The Planning Inspectorate

12 July 2023

Application by Equinor New Energy Limited for an Order Granting Development Consent for the Sheringham Shoal Offshore Wind Farm Extension Project and Dudgeon Offshore Wind Farm Extension Project

Request for Further Information

Figure 2: White-Clawed Crayfish Survey Results Map (River Wensum and Unnamed Tributary of River Wensum at Swannington)

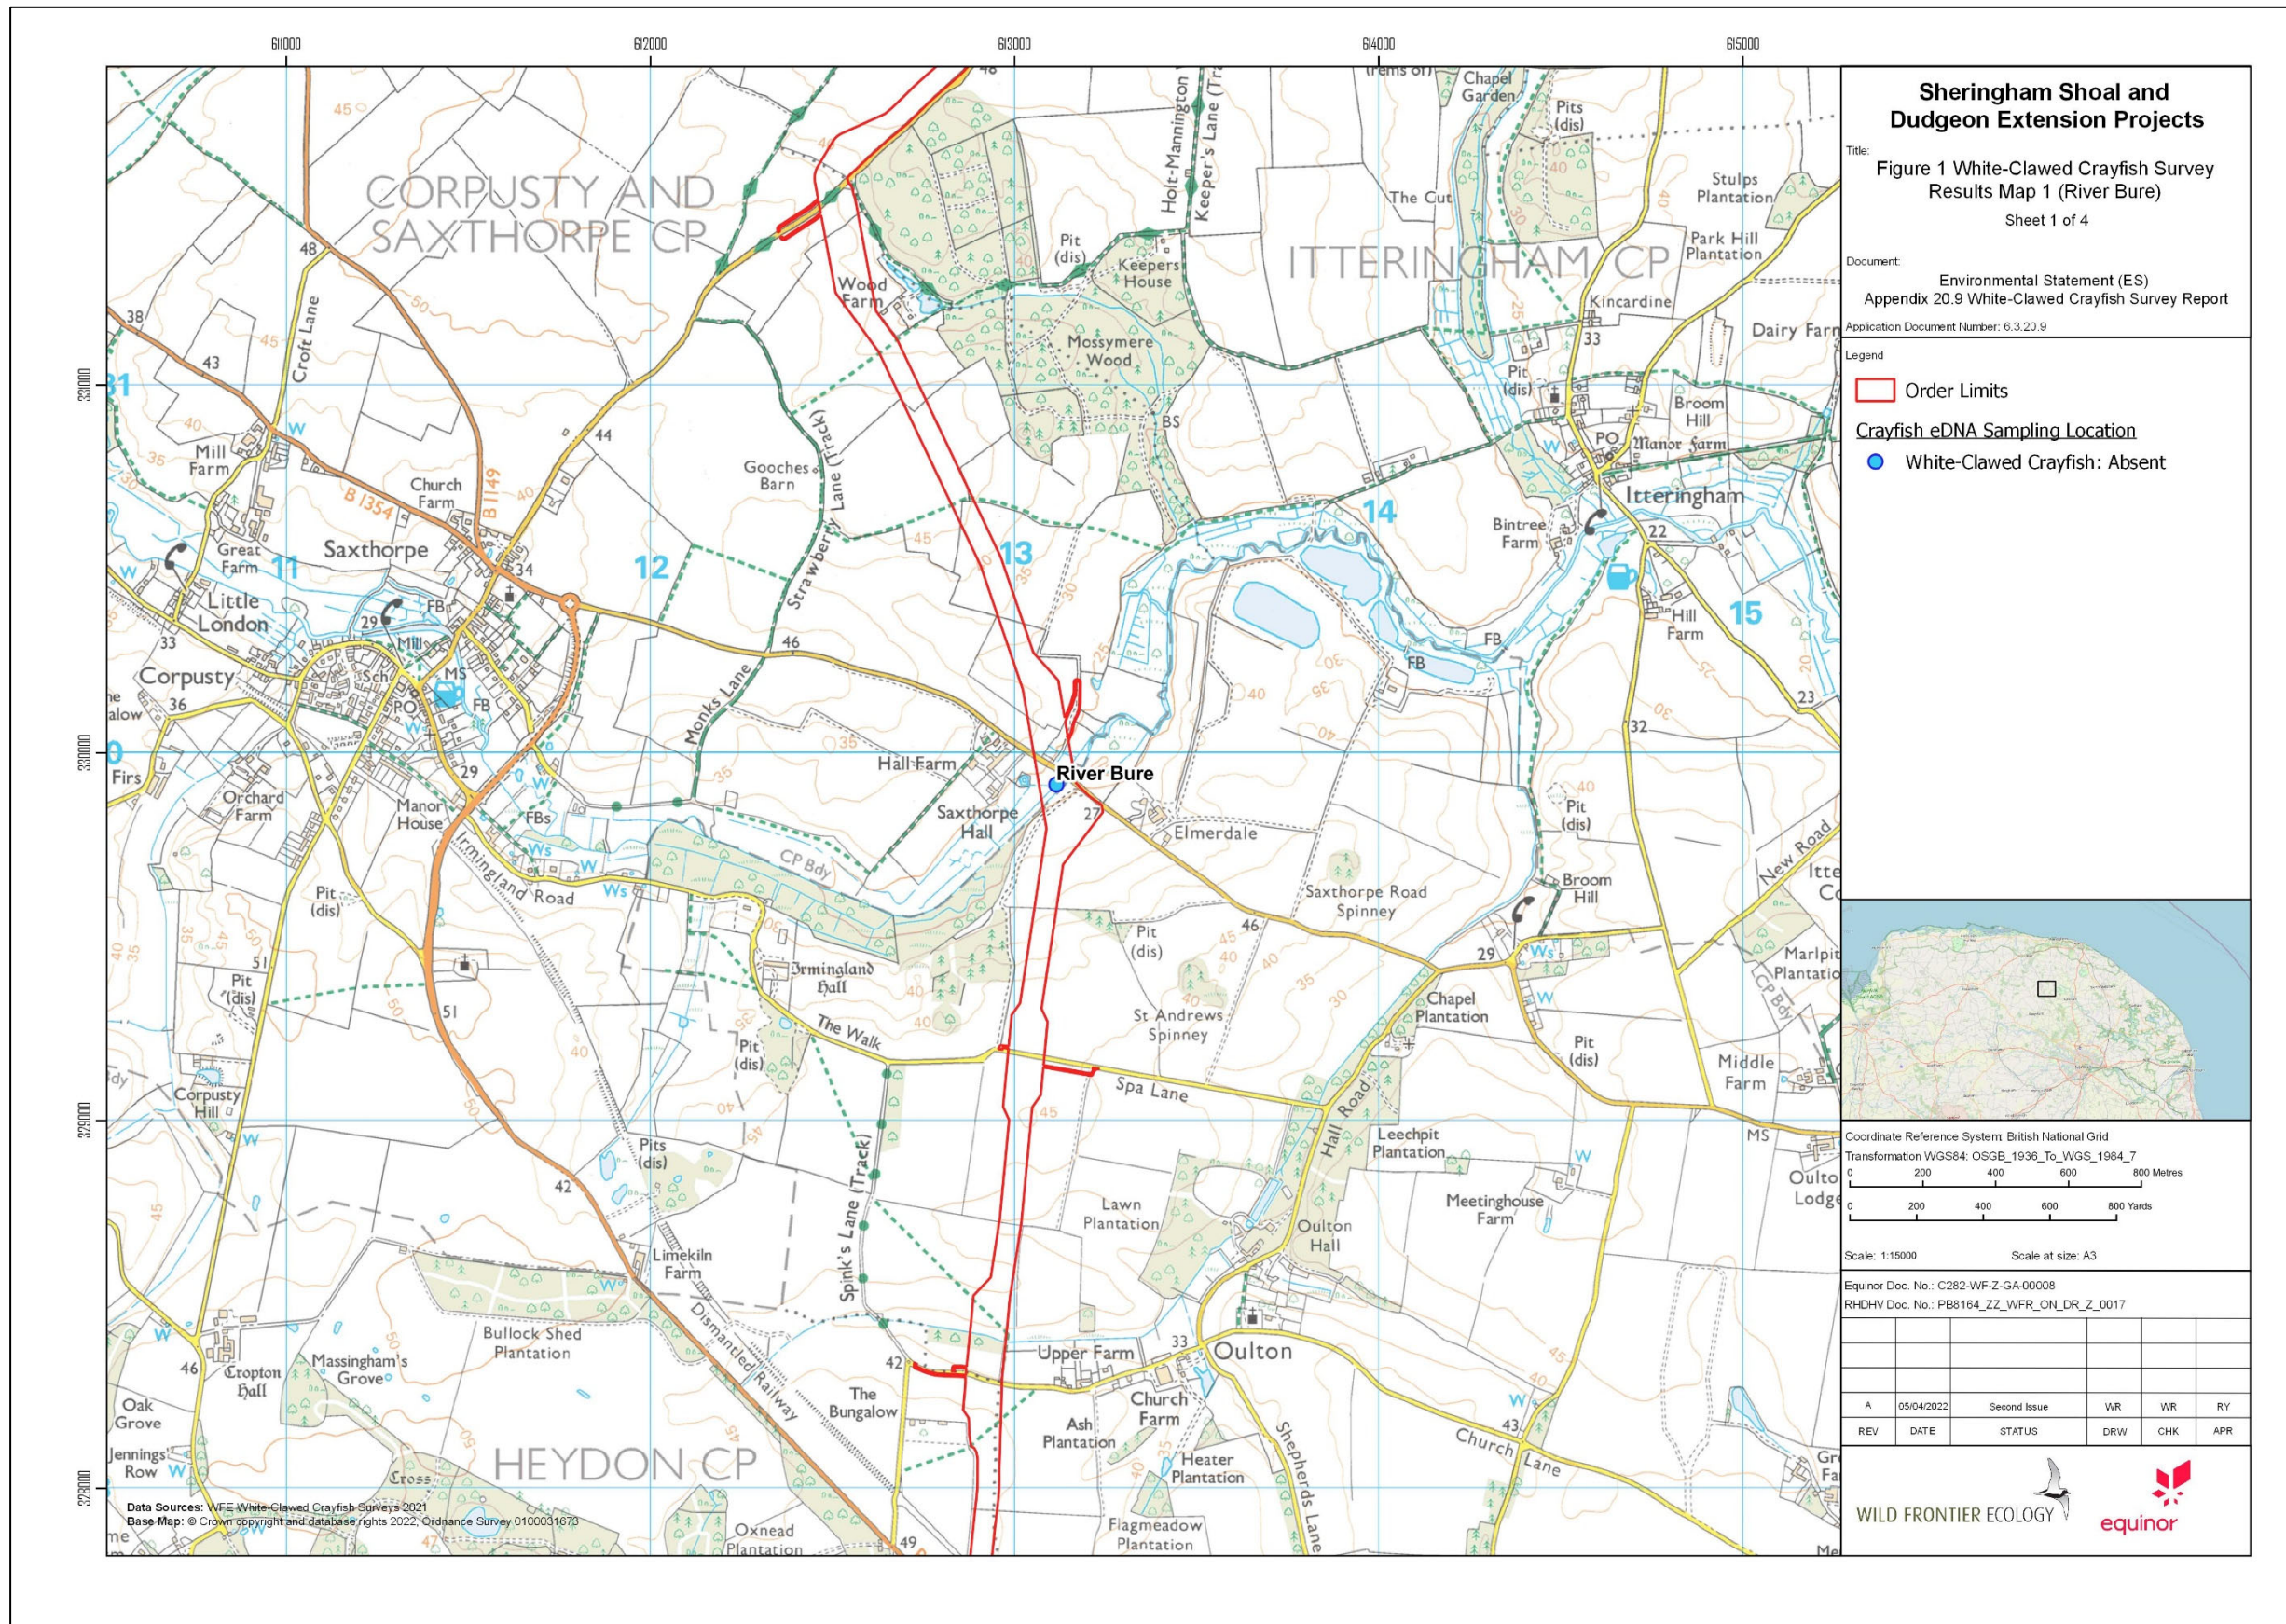
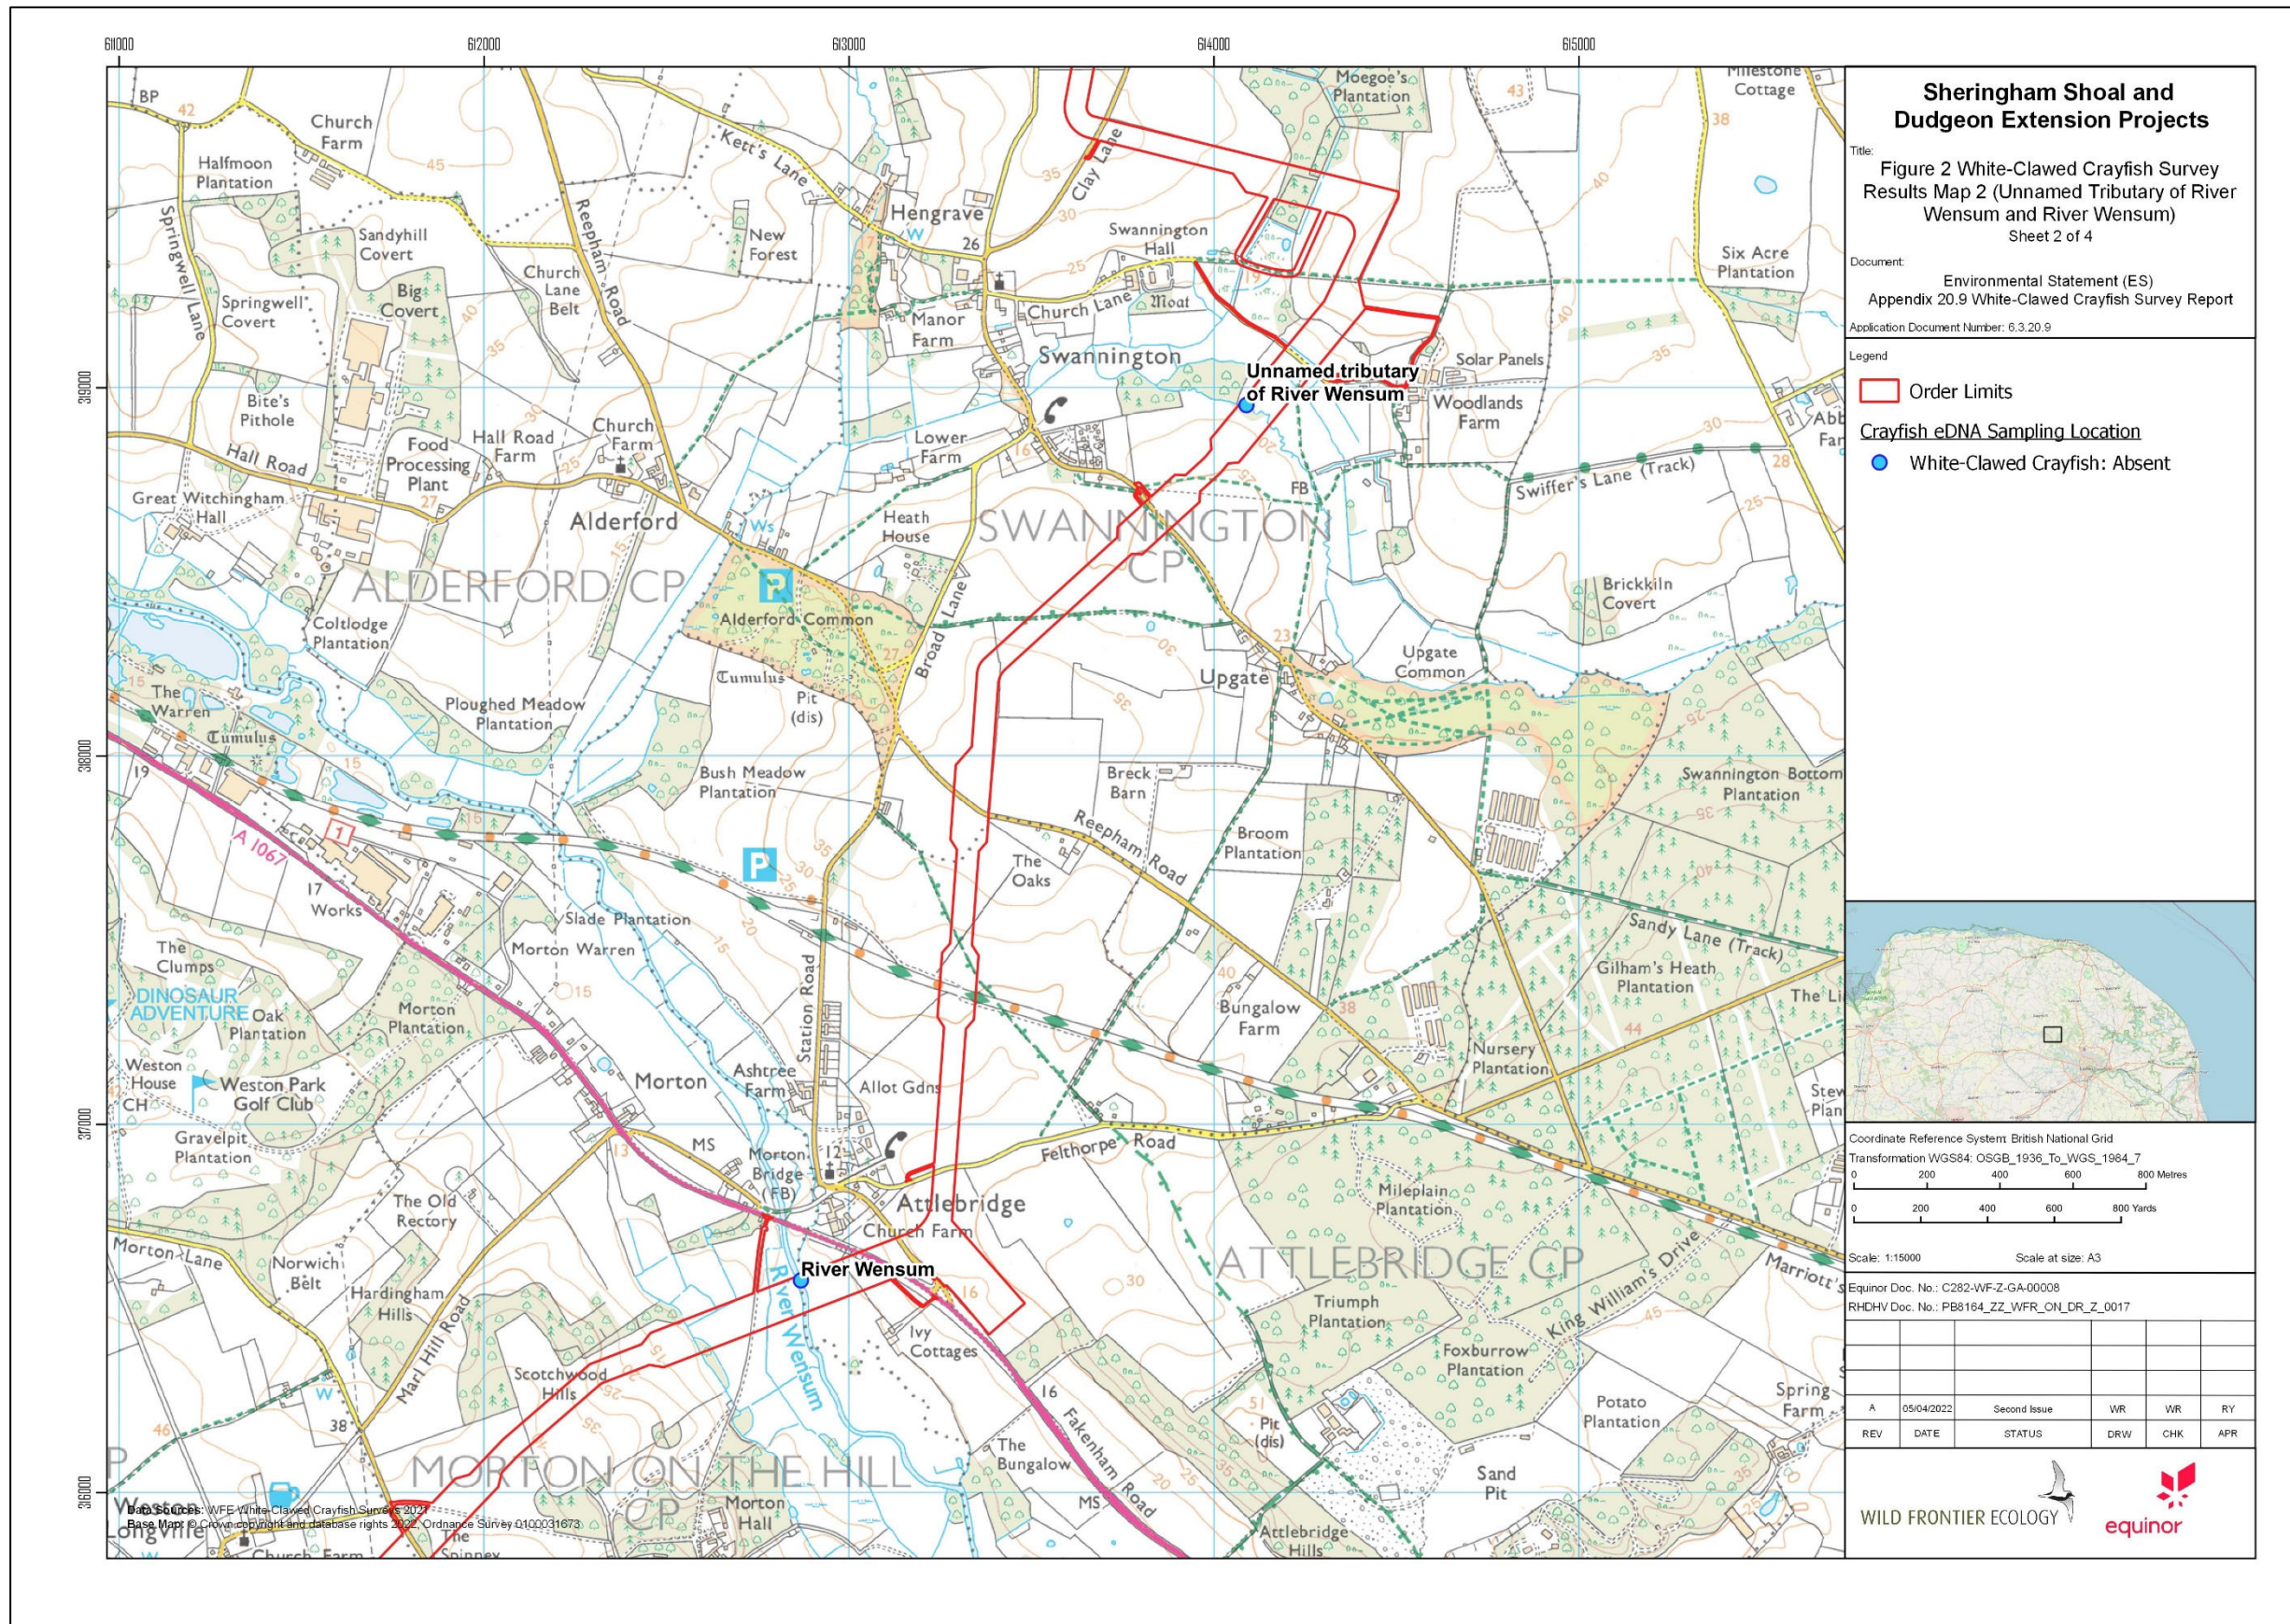
Respondent	Question
<p>Applicant</p> <p>Natural England</p>	<p>River Wensum Special Area of Conservation (SAC)</p> <p>a) Further to responses received to questions raised by the ExA from NE [REP5-094, Q3.12.2.3] and the Applicant [REP6-013, Q3.12.2.3], provide without prejudice wording for a Requirement within the dDCO which secures mitigation that removes or reduces the risk of AEol to the white-clawed crayfish, brook lamprey and bullhead features</p>

of the River Wensum SAC, before any work on the Proposed Development could commence.
Applicant Natural England	Pink Footed Goose Feature of North Norfolk Coast SPA b) Further to responses received to questions raised by the ExA from NE [REP5-094, Q3.14.1.17] and the Applicant [REP6-013, Q3.14.1.17], provide without prejudice wording for a Requirement within the dDCO which secures mitigation that removes or reduces the risk of AEoI to the pink footed goose feature of the North Norfolk Coast SPA and Ramsar site, before any work on the Proposed Development could commence.
Applicant Natural England	Wensum Woodlands c) Further to responses received to questions raised by the ExA from NE [REP5-094] and the Applicant [REP6-013, Q3.13.2] provide without prejudice wording for a requirement within the dDCO which secures mitigation that removes or reduces the risk of potential habitat loss and which ensures that the Proposed Development would not hinder any potential notification of Sites of Special Scientific Interest (SSSI) status to the Wensum Woodlands in the future. Alternatively, provide detailed reasoning which explains why such wording would not be required.
